Consultation Response from: KC Environmental Health (Pollution & Noise Control)		
2023/91280 Bromley Farm Quarry, Barnsley Road, Upper Cumberworth, Huddersfield, HD8 8PD		
Quarrying operations for the extraction of clay, shale and incidental coal and subsequent restoration by means of importation of inert wastes		
Date Responded: 9th November 2023	Responding Officer: RM	Responding Ref: WK/202332696
We have reviewed the application and submitted information and make the following comments and recommendations. Air Quality We acknowledge the submission of a new Air Quality and Dust Assessment by Miller Goodall (Dated: 3rd October 2023) (ref: 102882-2). It assesses the potential impacts associated with dust generating operations during the working of the new quarry, and the impact this will have on existing sensitive receptors. The assessment also considers changes in air quality caused by vehicle emissions namely HDVs (Heavy Duty Vehicles) travelling to and from the quarry. <u>Disamenity Dust</u> Dust from quarrying operations has the potential to impact local communities due to visible dust plumes and dust soiling of property. This courser visible dust is referred to by the Institute

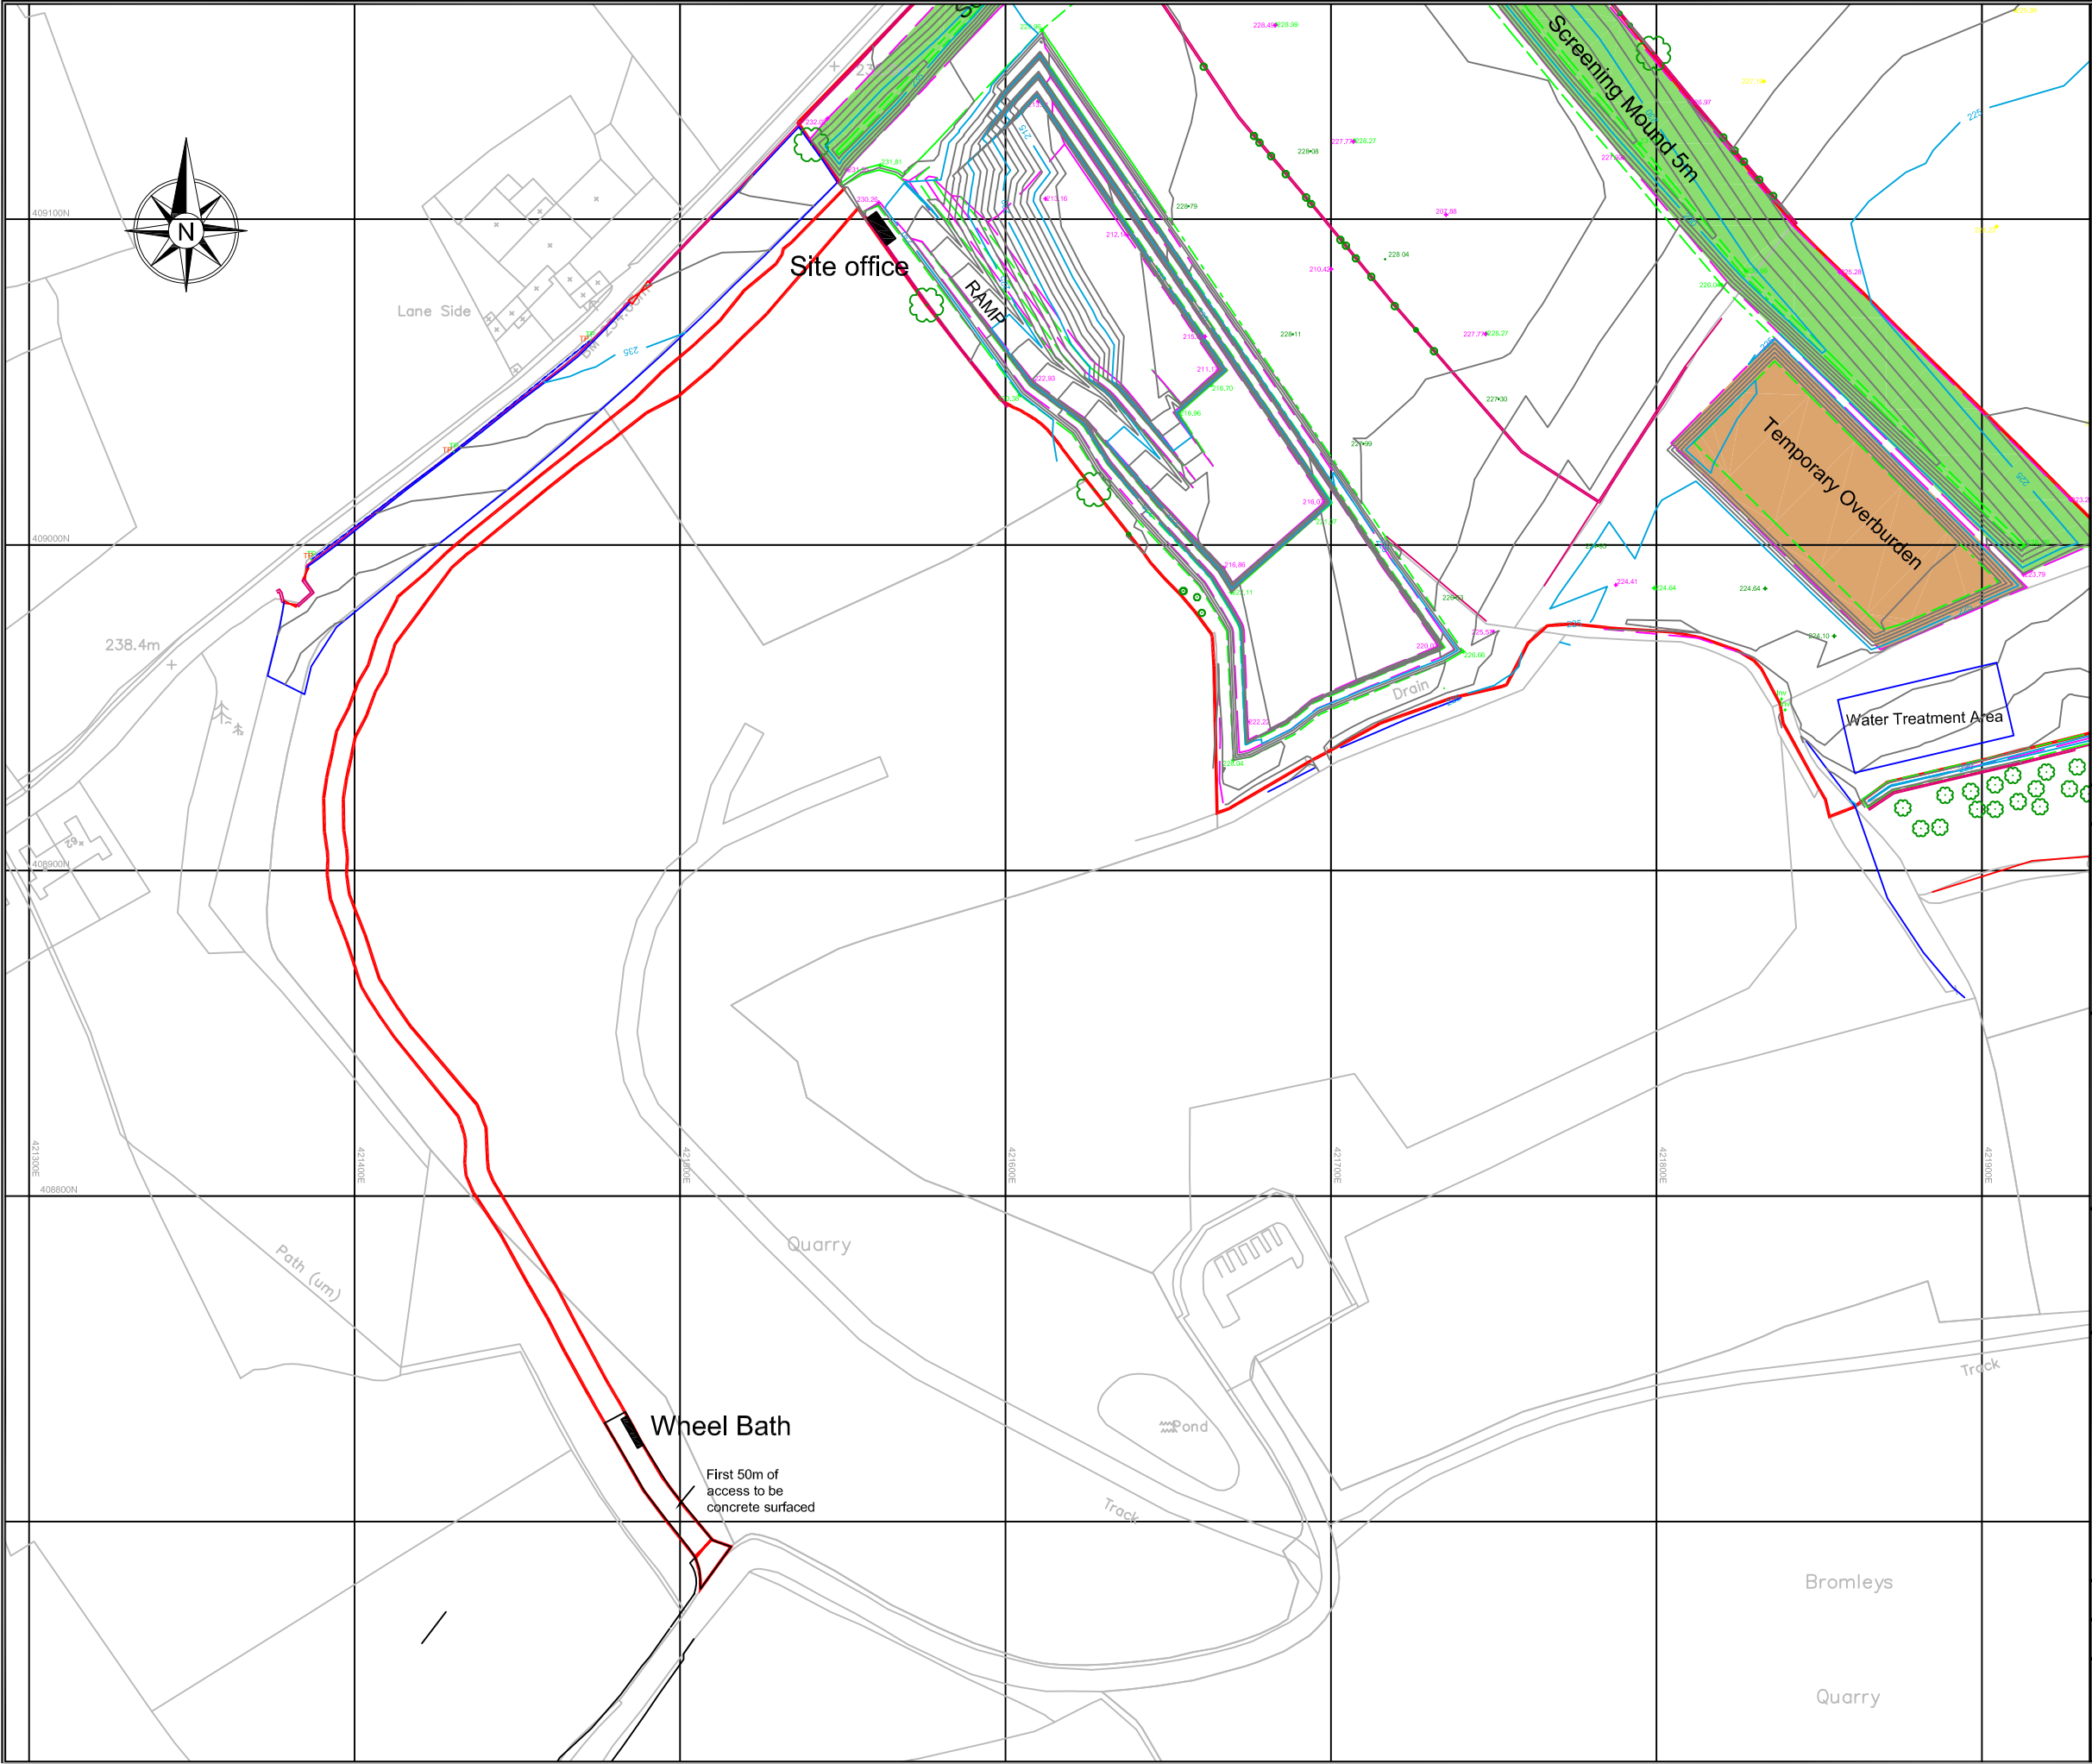
The Dust Management Plan provides a summary of operations at the extension site, and sets out the measures to control, mitigate and measure dust emissions throughout the lifetime of the operations to prevent loss of amenity to nearby sensitive receptors. We also note that in the plan titled 'Site Office & Wheel Bath Location' Dwg. No 22007/513 a permanent wheel bath fixture is proposed which has not been referenced in the Dust Management Plan.

Whilst we agree in principle with the Dust Management Plan, we would expect it to include the installation of a permanent wheel wash to avoid trackout from off-site transportation onto the main highway in accordance with the IAQM Guidance on the Assessment of Mineral Dust Impacts for Planning, Table 4 Good Practice Mitigation. We also note that in Table 1 of Appendix A that the water bowser will be checked to ensure that it is operating correctly on a weekly basis, and we expect that this is checked daily to comply with good practice dust mitigation. Therefore, we recommend the following conditions.

Before quarrying operations commence, details of the wheel bath fixture, as shown in the plan

titled Site Office & Wheel Bath Location Dwg. No 22007/513, including its location and maintenance shall be submitted to and approved in writing to the Local Planning Authority.
